Our Ref: LU/319/18/HH

**Town & Country Planning Act 1990 (as amended)
Town & country Planning (Development Management Procedure) (England) Order 2015
Application for Planning Permission for Works or Extension to a Dwelling**

Development Replace conservatory on rear elevation with single storey flat roof extension and new porch to side (north) elevation.

Location 16 Kent Road Littlehampton

GROUND FLOOR PLAN 1:50 @ A3

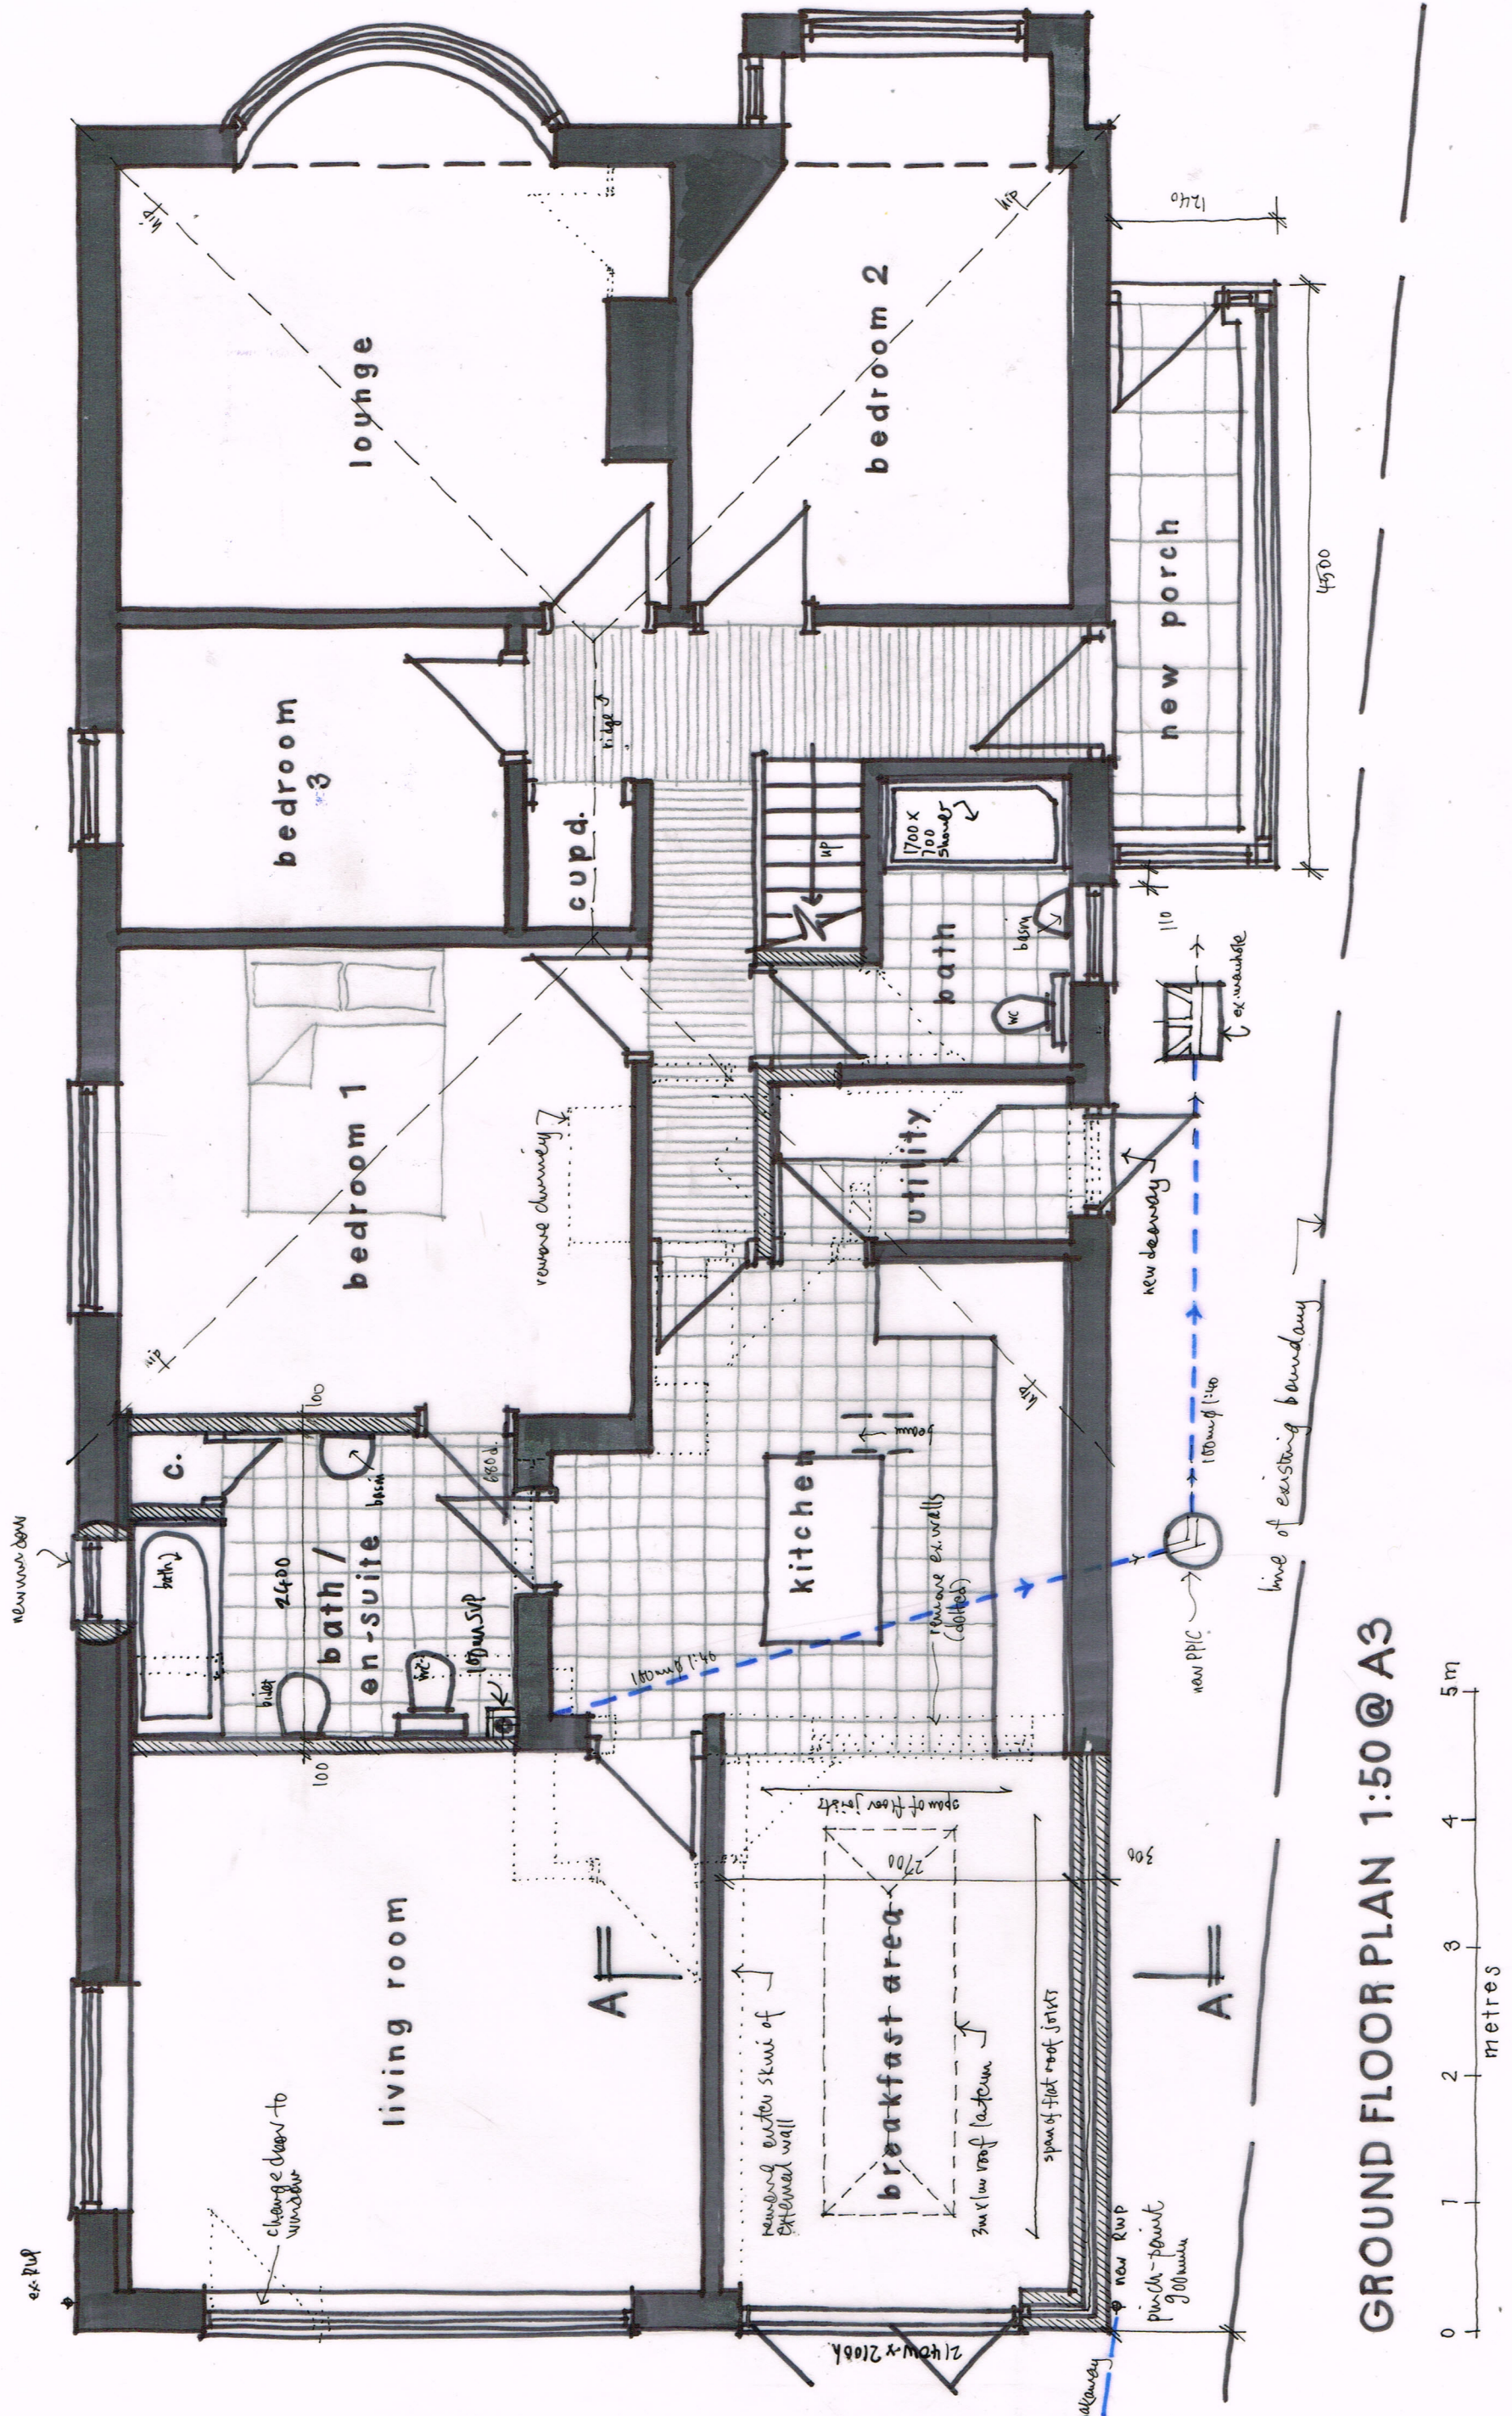
Plans Inconsistent: The position of the new window is inconsistent between the proposed floor plan and side elevation.

SITE PLAN 1:500 @ A4

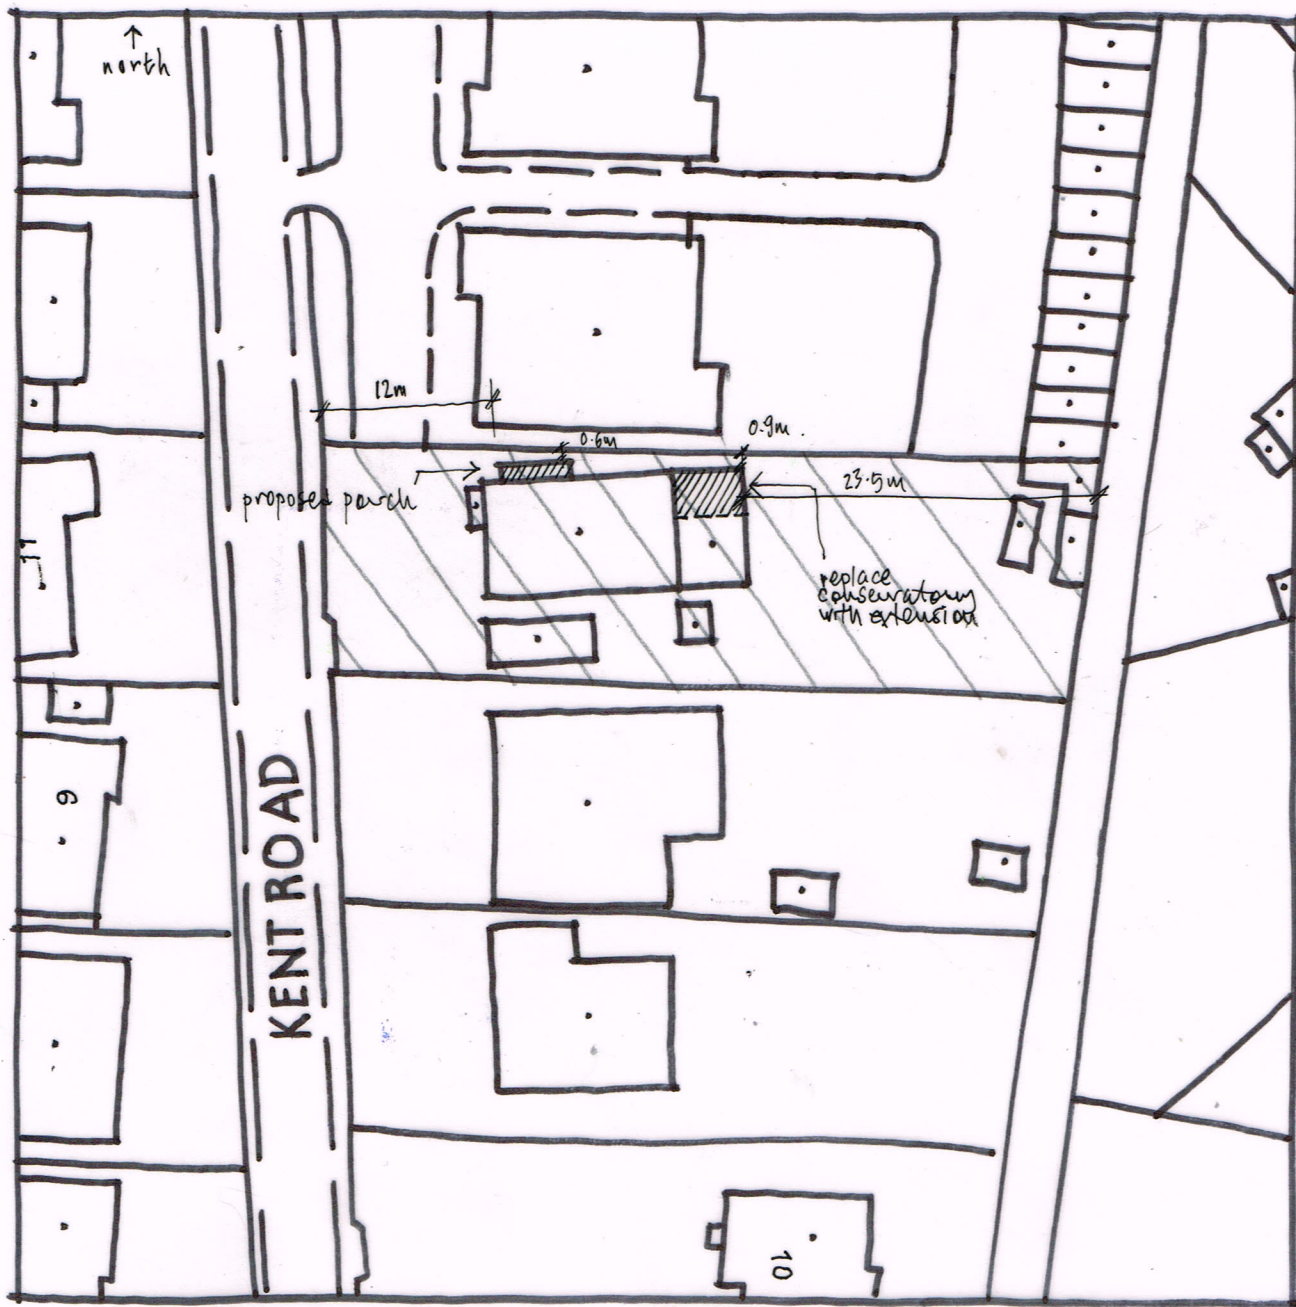
Dimensions: You are required to submit a block plan which includes all the dimensions to the boundaries. Please amend accordingly.
